SUBJECT: Engineering Review Comment  
Mountain View Electric Association Inc. (The Association)

**Project Name: 15435 E. Chaparral Loop – Lot 62, Peyton Ranches/Chaparral Heights**  
**Project Number: VR225**  
**Description:** Proposed development of 3 single family lots on approximately 17 acres located off E. Chaparral Loop in Township 11S, Range 63W, Section 33.

PEYTON RANCHES FILING NO. 1B
A REPLAT OF LOT 62 PEYTON RANCHES
LOCATED IN THE SOUTHWEST ONE-QUARTER OF SECTION 28 AND
THE NORTHWEST ONE-QUARTER OF SECTION 33,
TOWNSHIP 11 SOUTH, RANGE 63 WEST OF THE 6TH PRINCIPAL MERIDIAN
COUNTY OF EL PASO, STATE OF COLORADO.

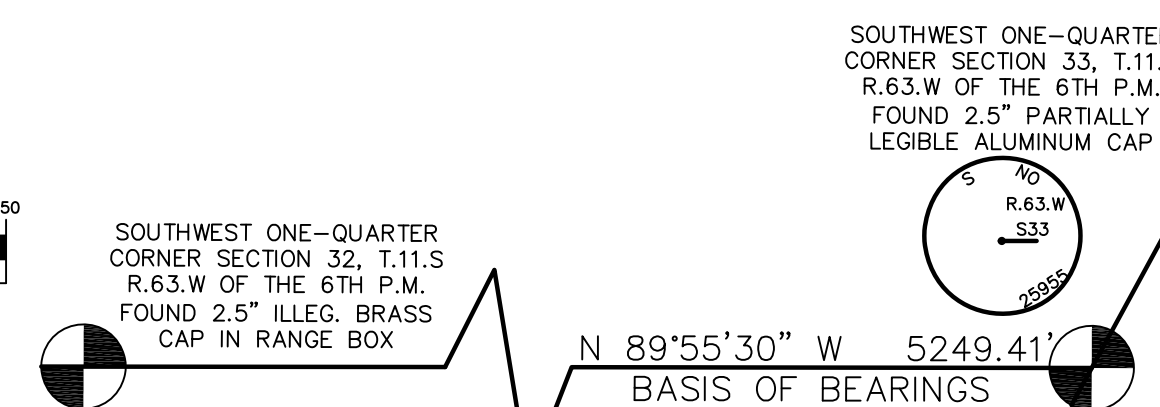
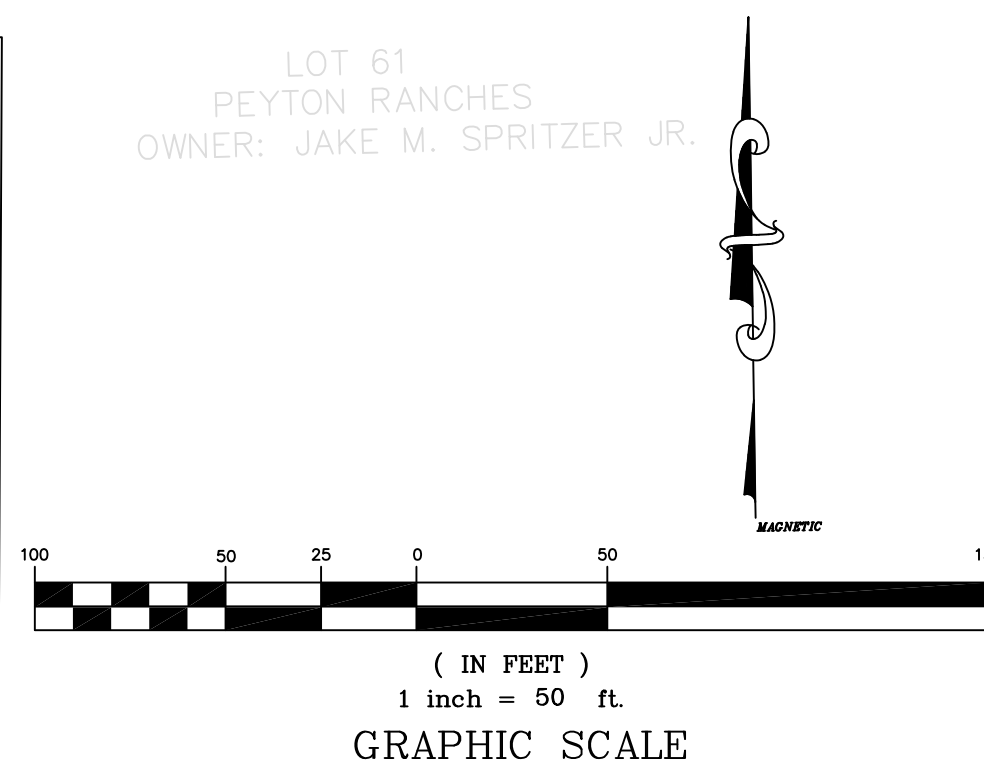
The Association requests a ten (10) foot front, side, and rear lot utility easement and all tracts, along with a twenty (20) foot exterior utility easement on the plat. The Association also requests the platting of the Association's existing facilities with easements on the plat. Additional easements may be required. All easements will transfer with the property.
